Arun District Council
Arun Civic Centre
Maltravers Road
Littlehampton
West Sussex BN17 5LF
Planning & Building Control General Enquiries
Tel: (01903) 737756 Fax: (01903) 730442
Dx: 57406 Littlehampton
Minicom: 01903 732765
e-mail: planning@arun.gov.uk
website: www.arun.gov.uk/planning

6th July 2020

Application No: CM/16/20/PL
Site Address: Langford Horsemere Green Lane Climping BN17 5QZ
Description of works: Variation of condition 2 imposed under CM/64/19/PL to substitute House Type F floor plans & House Type F elevations.

Drawing Title:
HOUSE TYPE-F1
FLOOR PLANS

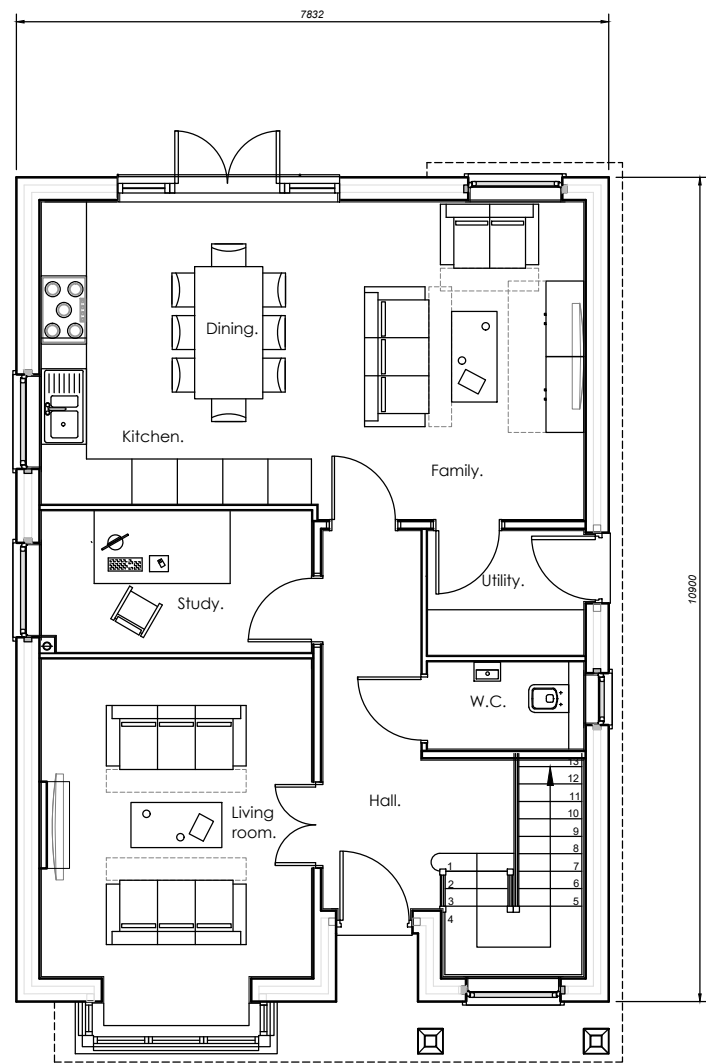
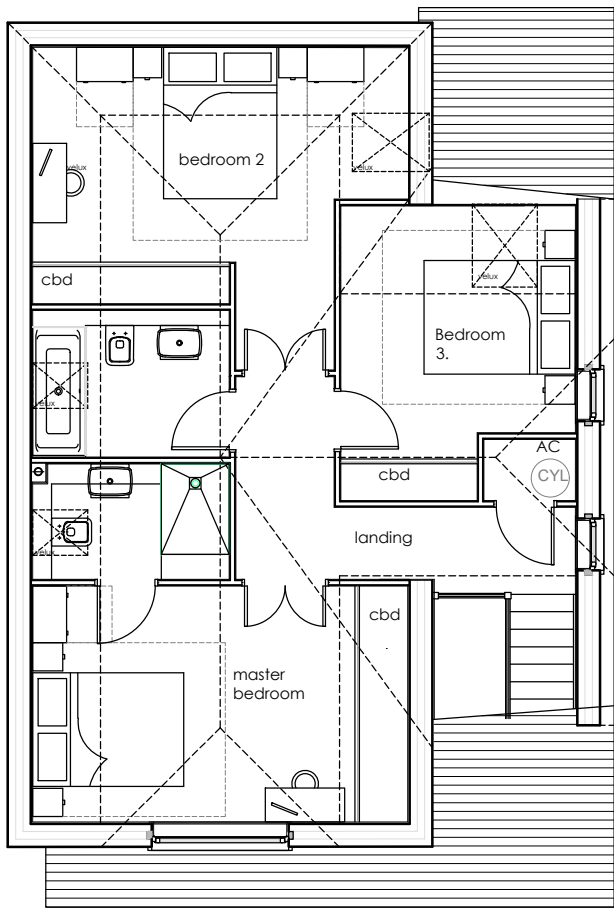
Council's objection to the original application (CM/64/19/PL) for 9 houses on the Langford site is a matter of public record. In their response to this objection the agent asserted that the concern over privacy in relation to plot 8 had been resolved through agreement with the planning officers with a substitute design of a chalet bungalow rather than a 2 storey house (plan drawing 190725/HT/F/EL). This was to ensure the homes in Appletree walk retained quote total privacy. The application was approved conditionally on the basis of the submitted plans but this new application seeks to vary this condition with a return to a 2 storey building on plot 8.

Council feels that this is an unacceptable retrograde step and fully supports the objections of residents to this application. Council reiterates its previous objection relating to the loss of privacy due to the overlooking of neighbouring properties that this proposed change will create and that the proposal is contrary to Arun's draft Design Guide.
